Observation on a Strategic Infrastructure Development Application

Martin Mc Namara

Purpose		PLANNING			
Title		SITE ACCESS SIGHTLINES			
Original Scale	Design/Drawn	Checked	Authorised		
SHOWN at A1	PS	ND	AJB		
Date	Date	Date	Date		
01.12.25	01.12.25	01.12.25	01.12.25		
Status	Drawing Number	Rev			
A2	PEK3-ATK-ZZ-01-DR-CE-901200	0

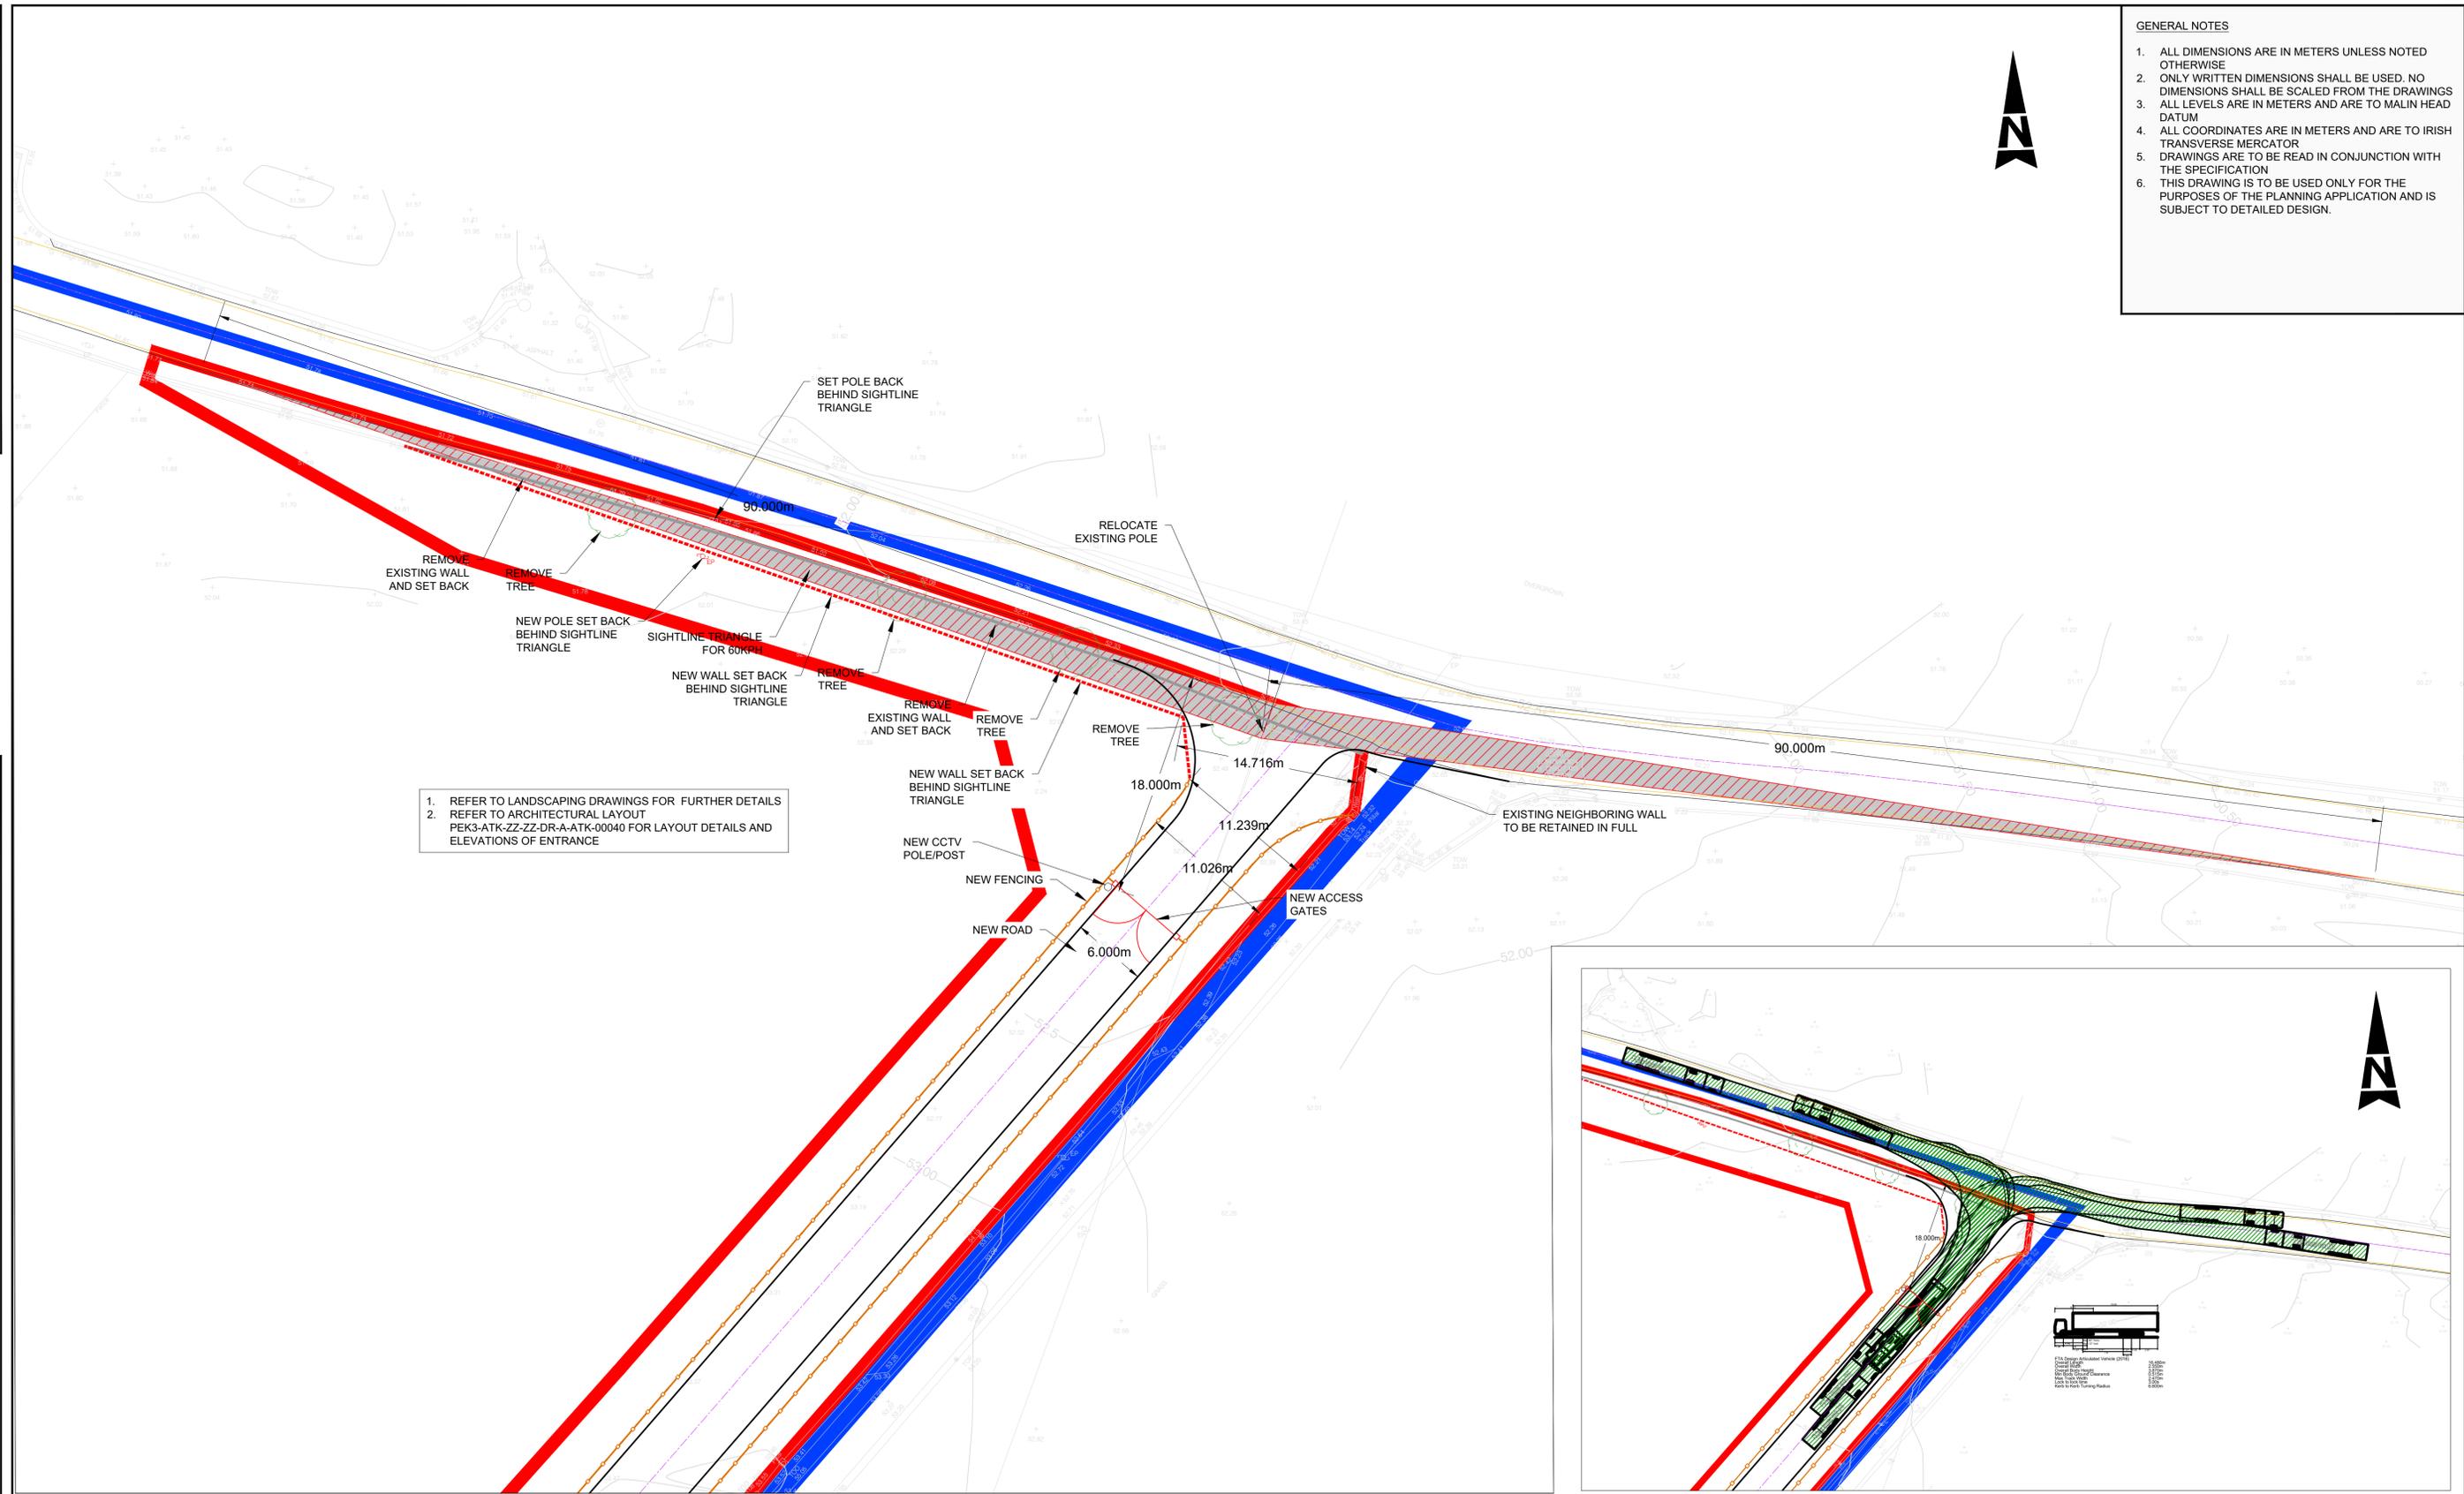
The current road layout does not facilitate safe access and egress for articulated vehicles. Due to the restricted road width and geometry, articulated vehicles will be required to cross onto the opposing carriageway in order to enter and exit the site. This manoeuvre would place such vehicles directly into the path of oncoming traffic, creating an unacceptable road safety risk.

This issue is particularly concerning given the anticipated frequency of HGV movements and the limited visibility available on the local road network. In my view, the existing access arrangements do not comply with safe road design principles and would pose an ongoing risk to all road users.
